**WEST SUSSEX COUNTY COUNCIL
PLANNING SERVICES CONSULTATION**

SUBJECT: WA/76/17/PL - 5 No. dwellings with associated car parking, garaging, landscaping & bin storage & the creation of 2 No. new accesses onto Wandleys Lane. This application is a Departure from the Development Plan.

**Land South of Wandleys Farm, Wandleys Lane, Walberton, West Sussex,
BN18 0QR**

Amended Information has been received in the form of revised Tree Reports, block plans and Transport Statement.

2.4 x 6.8m VISIBILITY SPLAYS
SEE TRANSPORT PLAN FOR MORE DETAILS

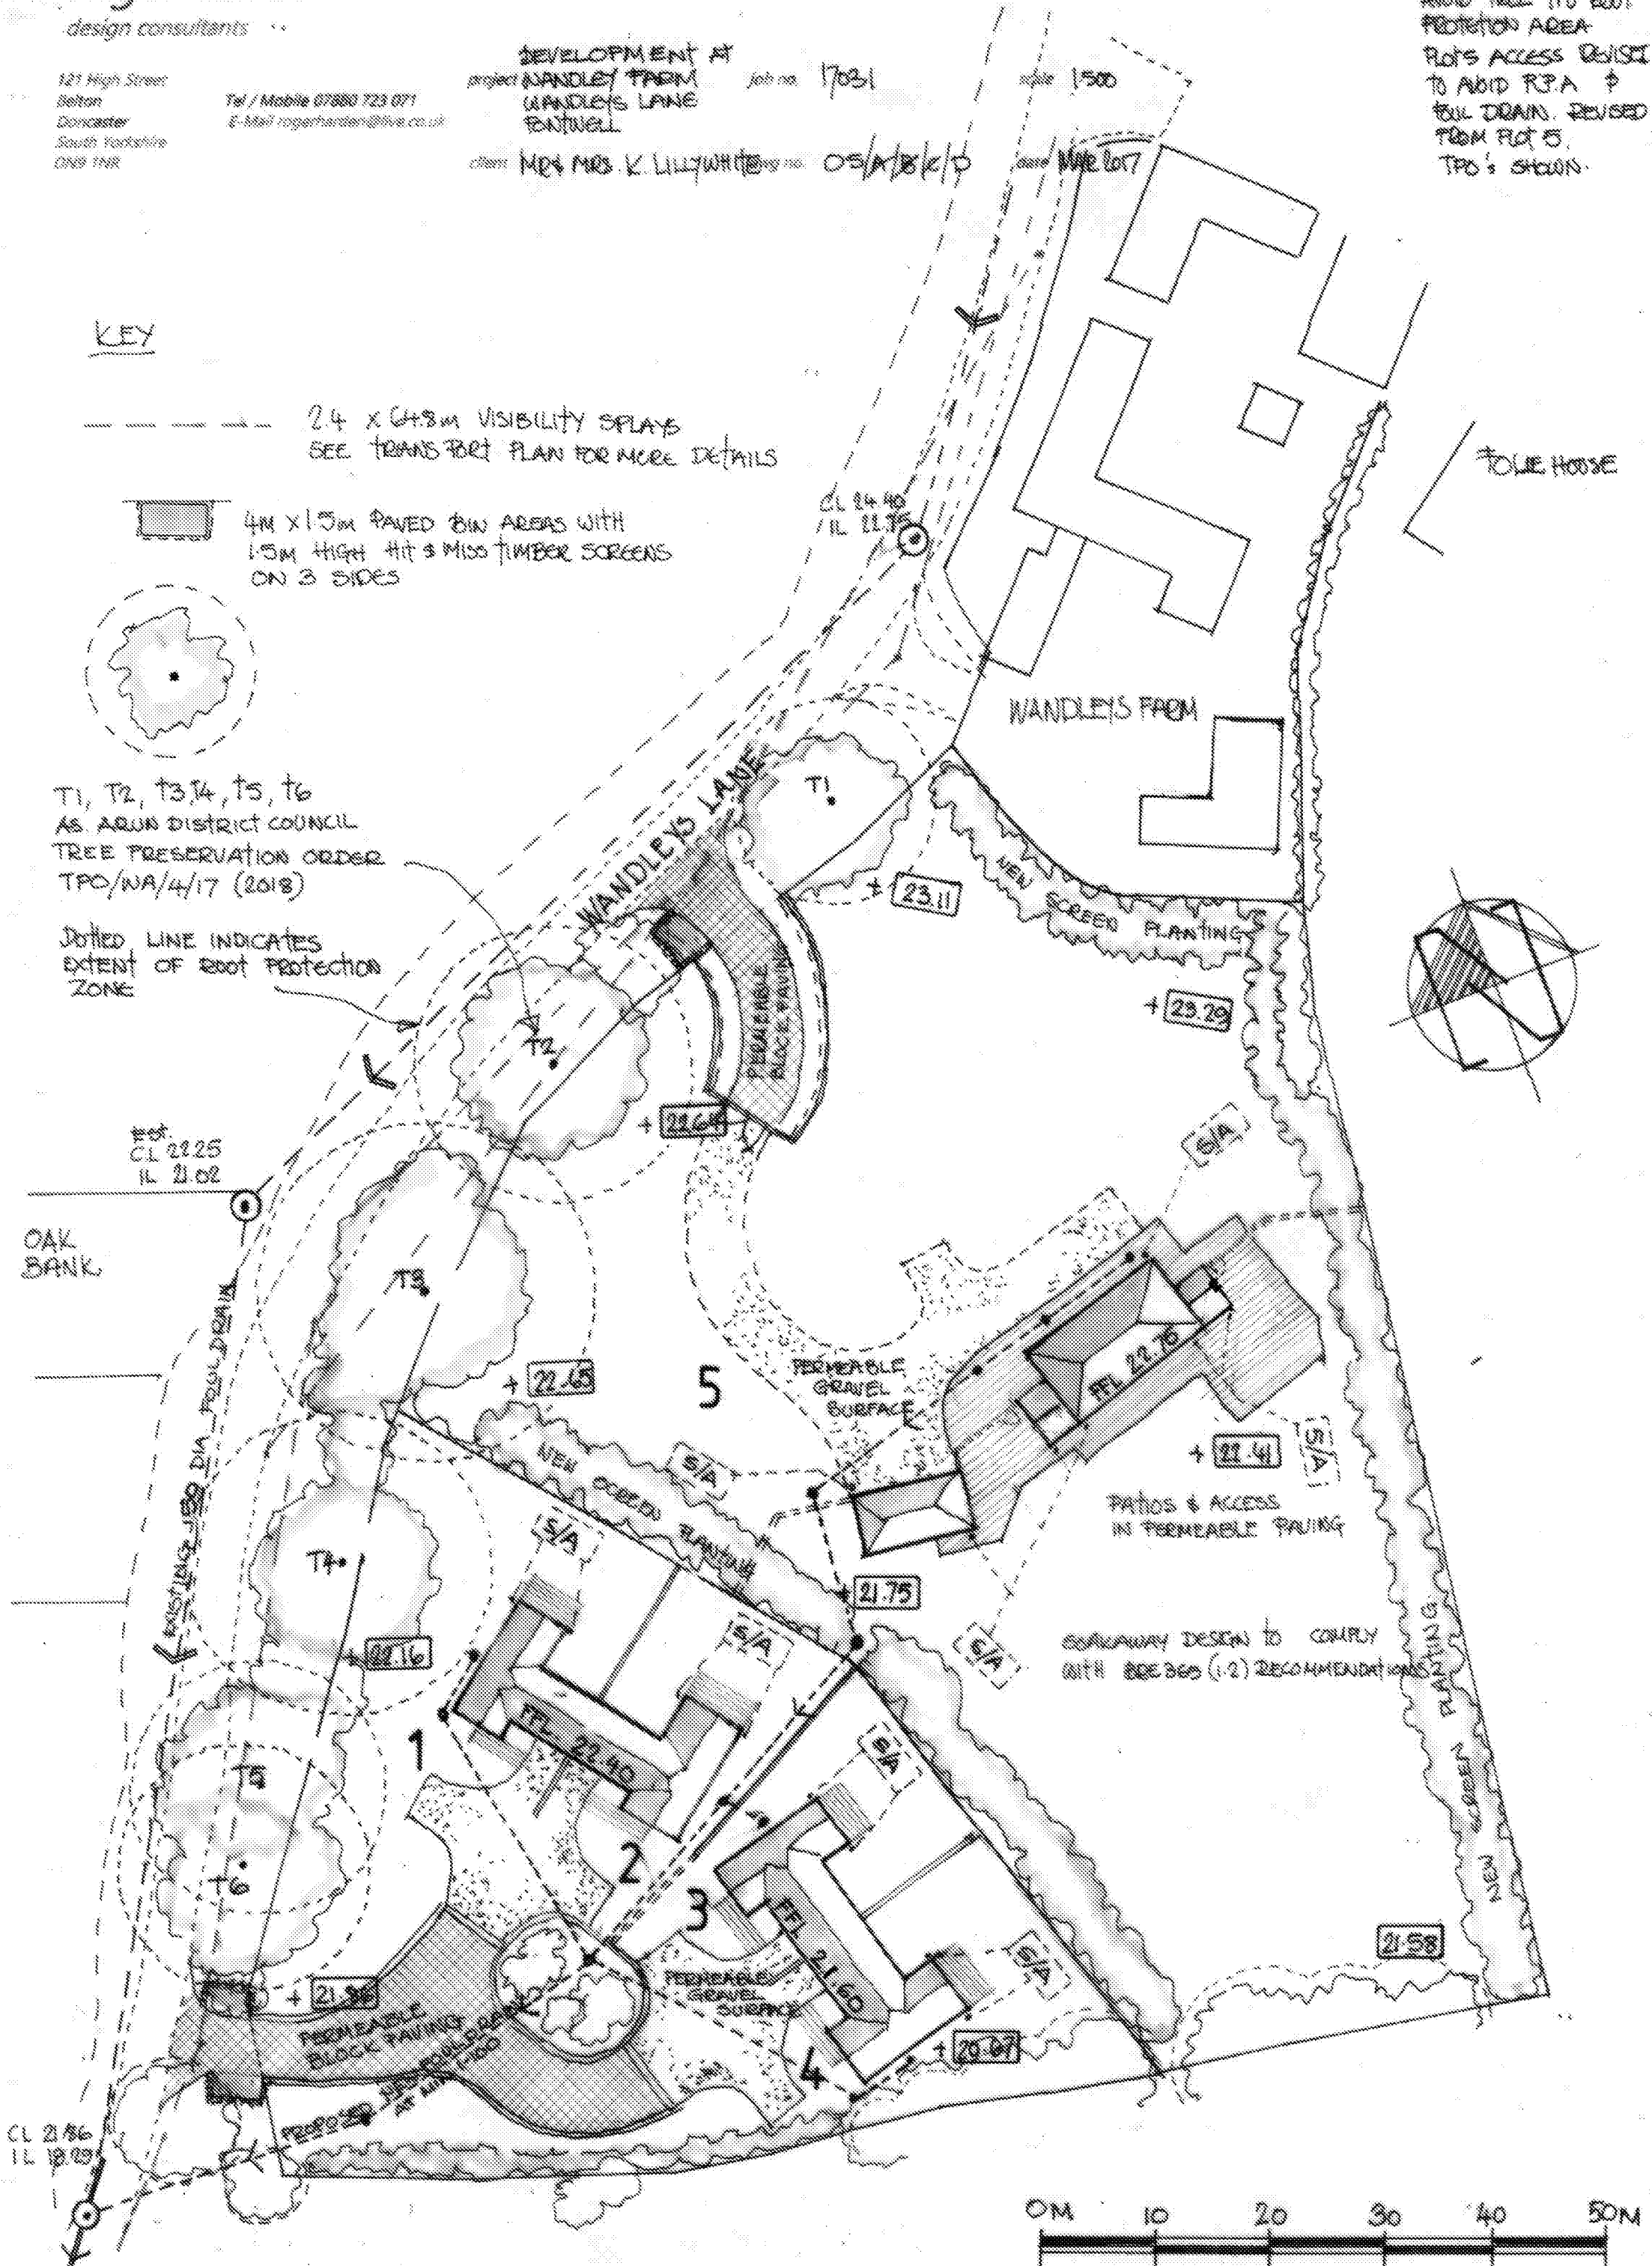
The effect of the revisions on the application is to move the access for a single dwelling northward by approximately 20m. The access can still achieve visibility requirements of 64.8m x 2.4m. It is not that the visibility splay southwards runs under the canopy of 'Tree 2' however given the height of the canopy no concern is raised.

I am content to rely on the conclusion and conditions outlined in my previous response dated 20th of November 2017.
